KIRKLEES METROPOLITAN COUNCIL INVESTMENT & REGENERATION SERVICE

DELEGATED DECISION TO DETERMINE PLANNING APPLICATIONS

Reference No:	2024/62/91169/W
Site Address:	former House of Fraser, Kingsgate Centre, King Street, Huddersfield, HD1 2QB
Description:	Alterations to existing building facade, removing existing glazed shopfronts and replacement with new shopfronts and entrances
Recommending Officer:	Joanna Rednall

Officer Report – 2024/91169

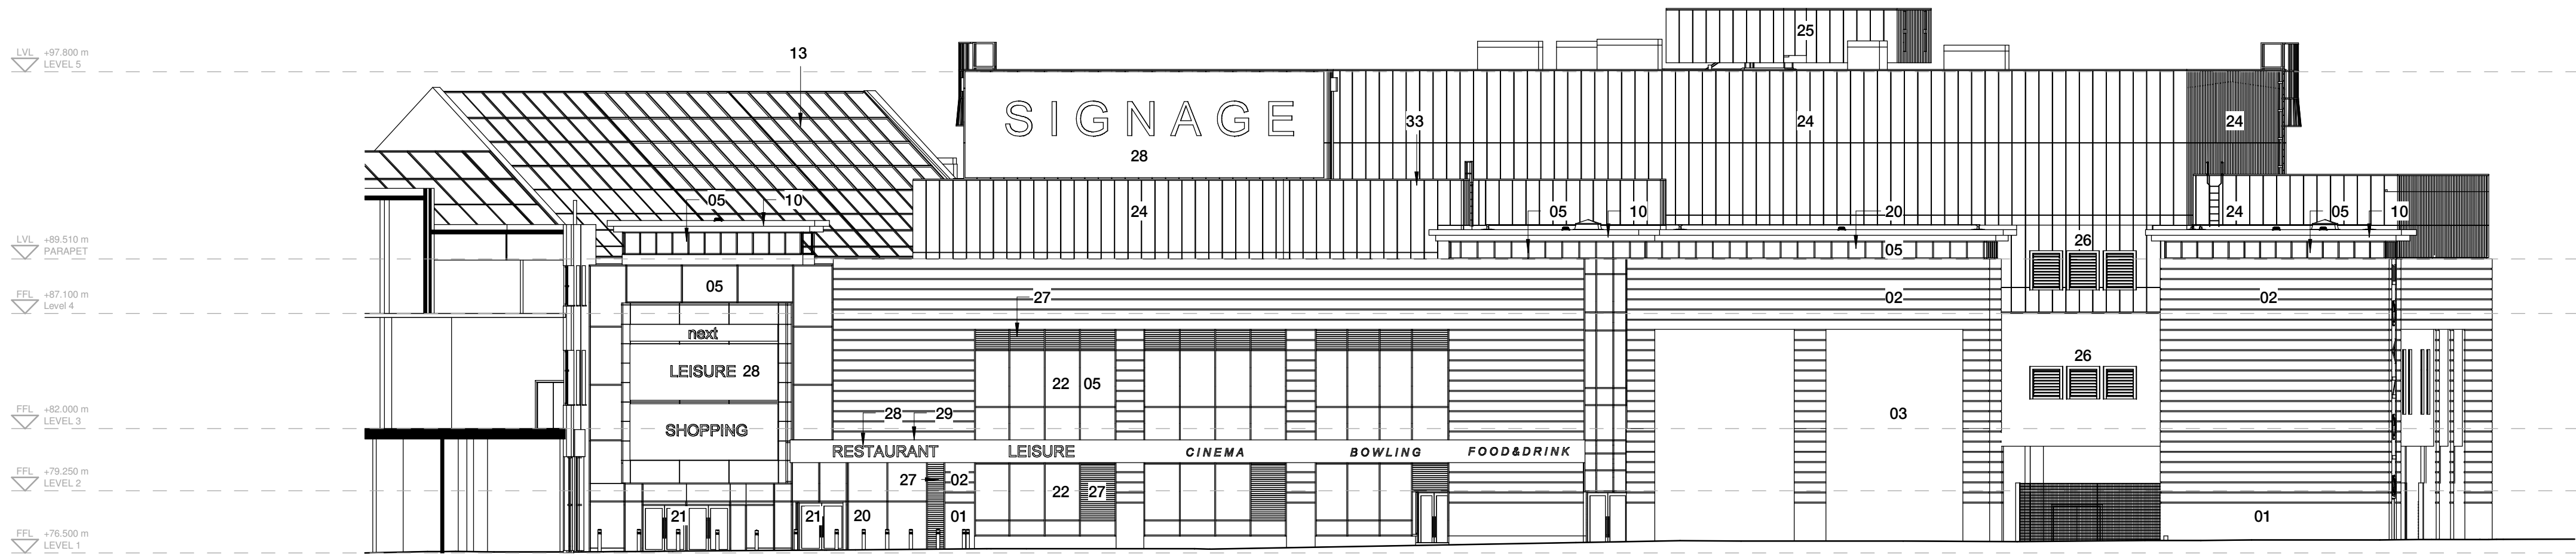
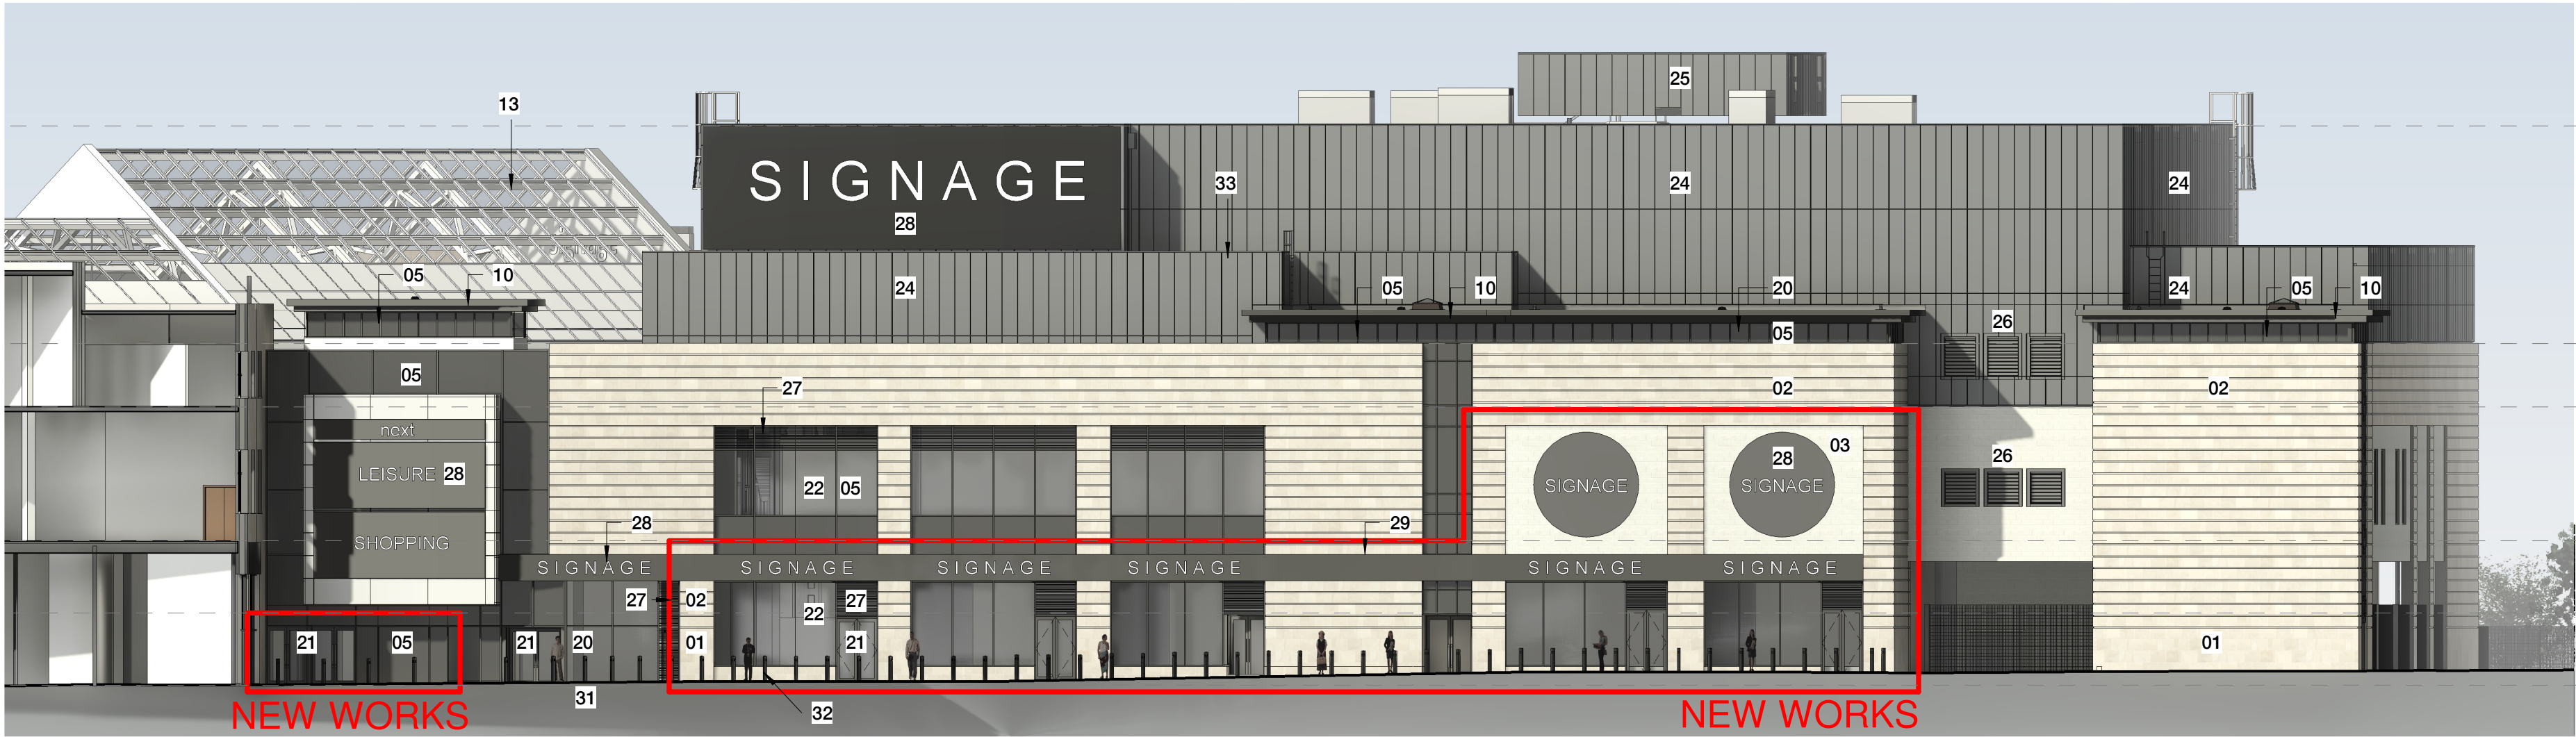
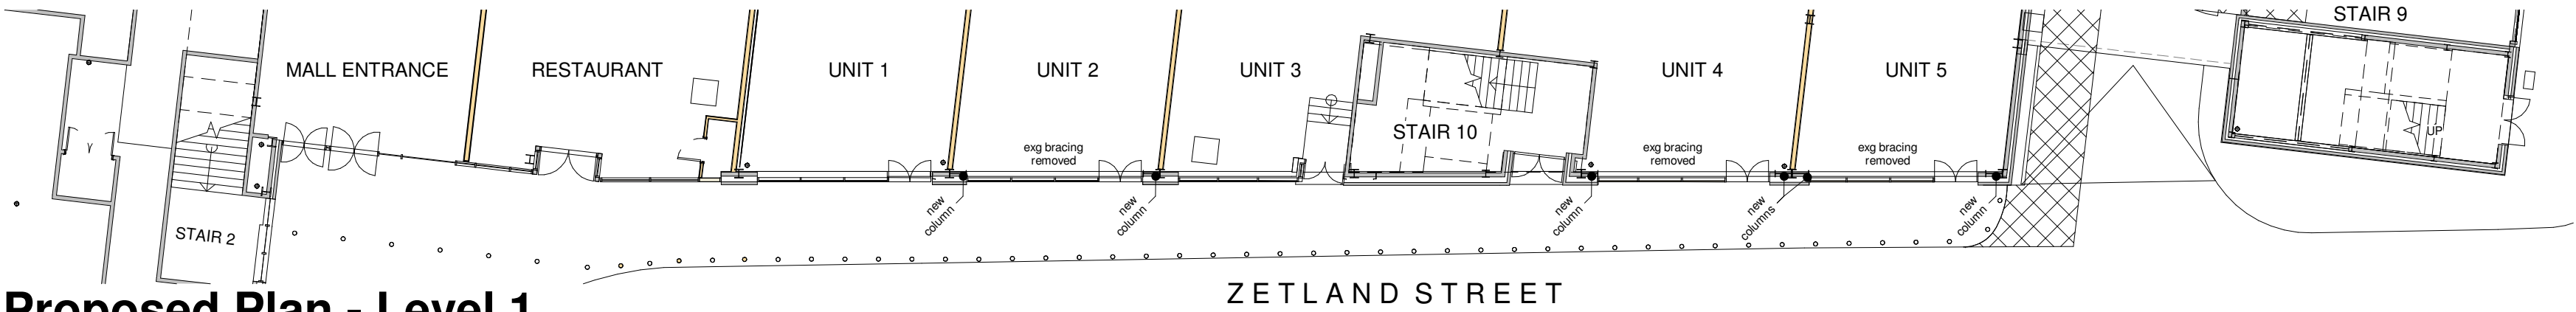
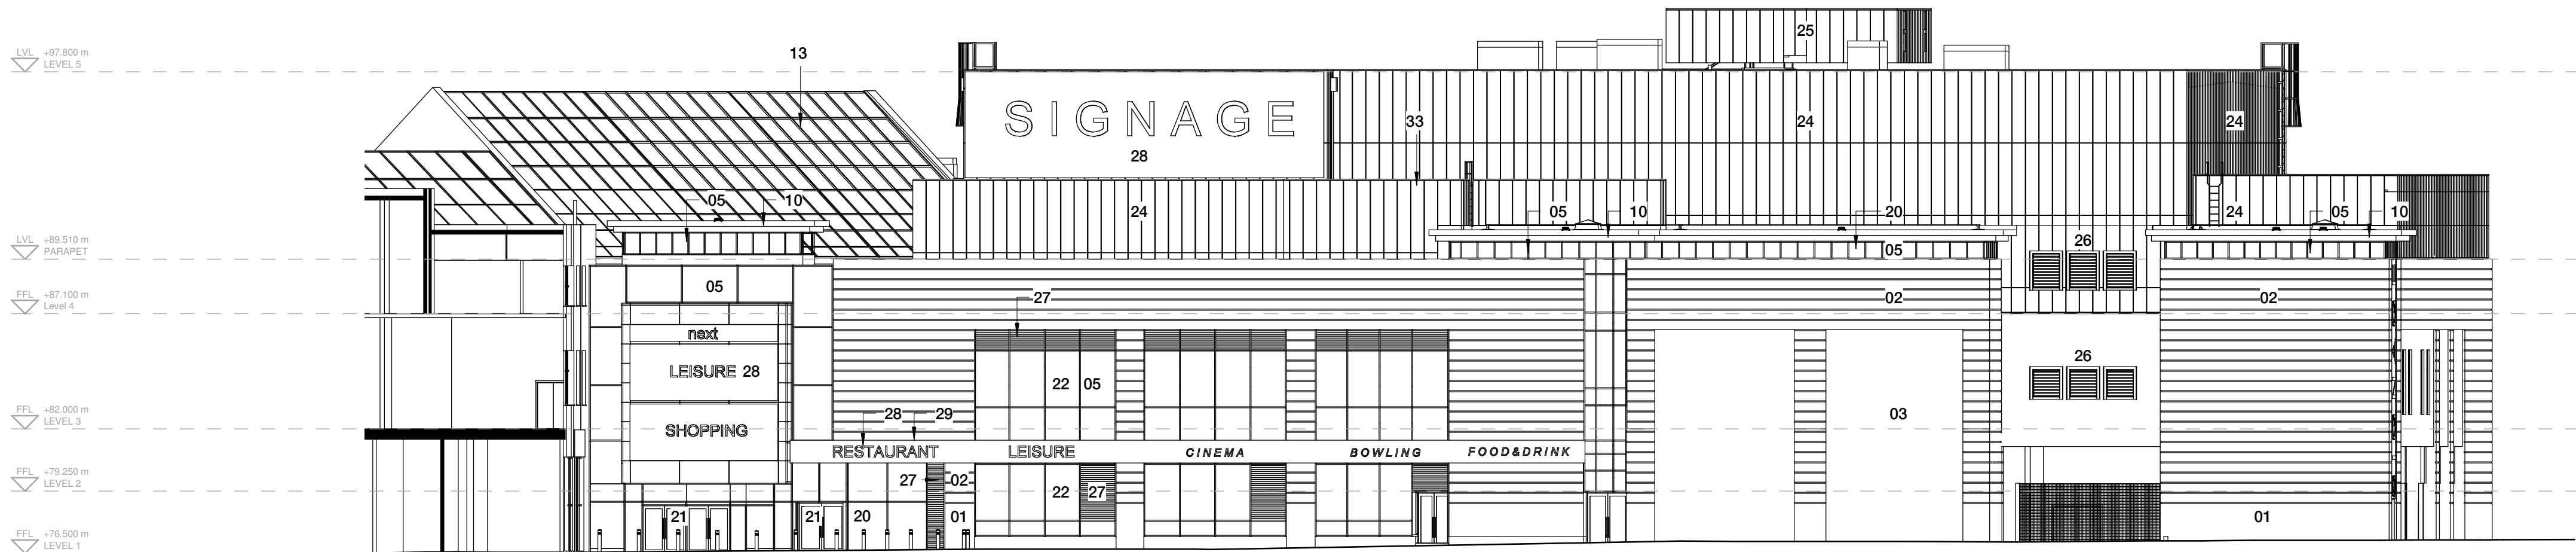
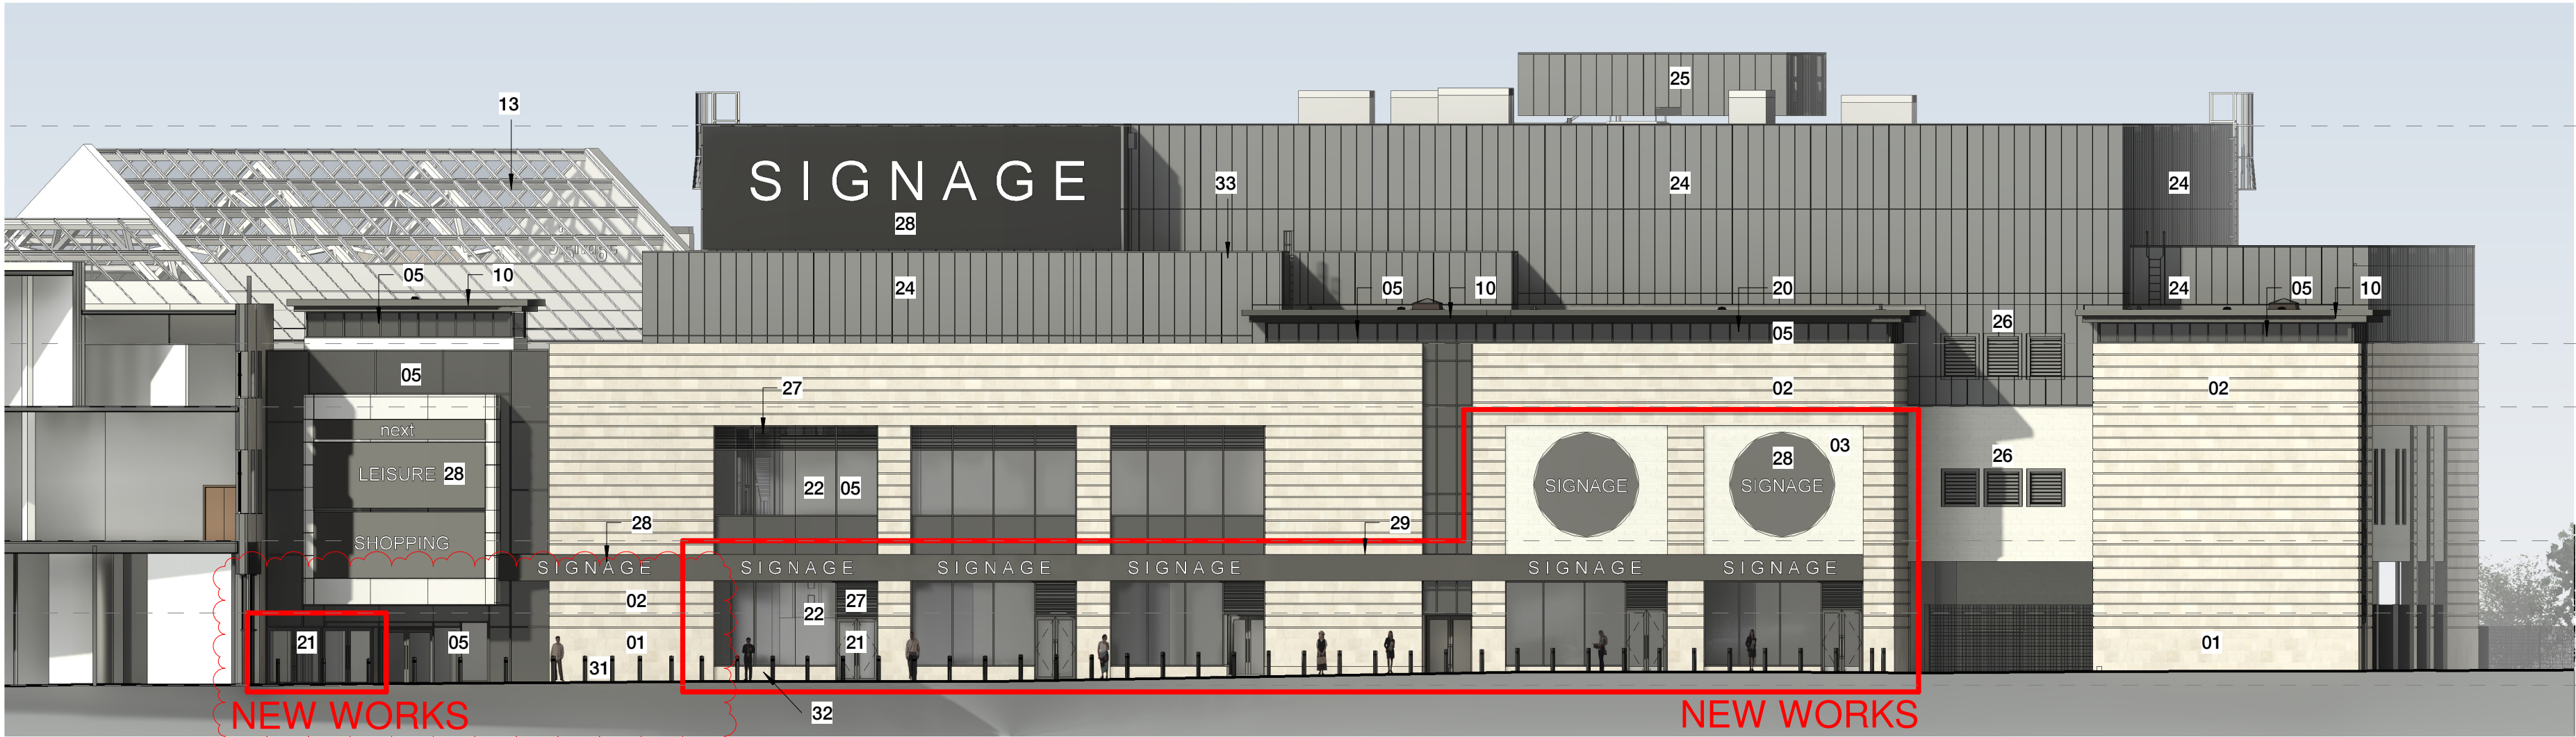
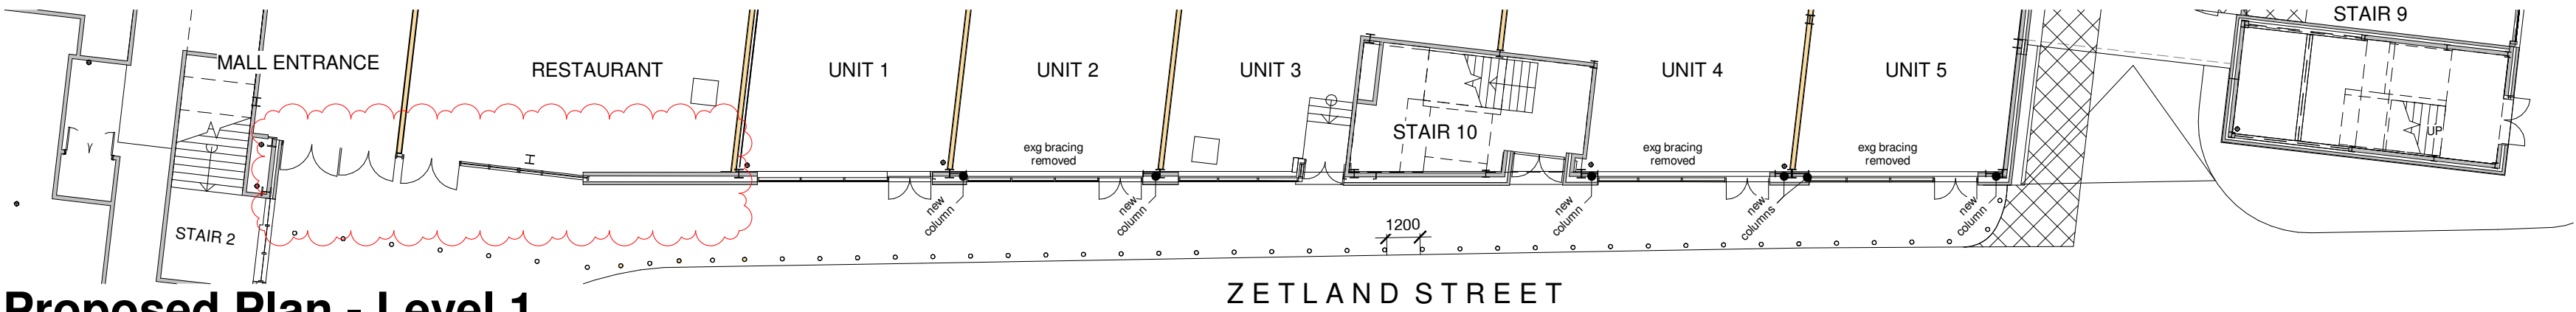
KC Highways (informal) – Initial concerns were raised regarding the spacing of the bollards and its impact on the site's accessibility. Revised plans were submitted to address these comments that have been used in the determination of this application.

Bollards are proposed along the west-facing elevation of the pavement and finished in black to match the existing. Initial concerns were raised by KC Highways with regards to the spacing of the bollards and the potential impact on accessibility to and from the public highway. The applicant successfully amended the plans by increasing the spacing to 1.2 meters in response to these comments. The site faces an adopted highway, and as such bollards are a common feature within the street scene and these additions would contribute towards creating an active ground floor usage within a Primary Shopping Area. The bollards are proposed to be finished in black, and it is therefore considered to be reasonable and appropriate to impose a condition to ensure that the color is secured by a condition.

KC Highways DM have been informally consulted as part of this application. They raised concerns initially regarding the spacing between the proposed bollards to ensure the shopfront was accessible. The applicant successfully amended the plans to reflect these comments.
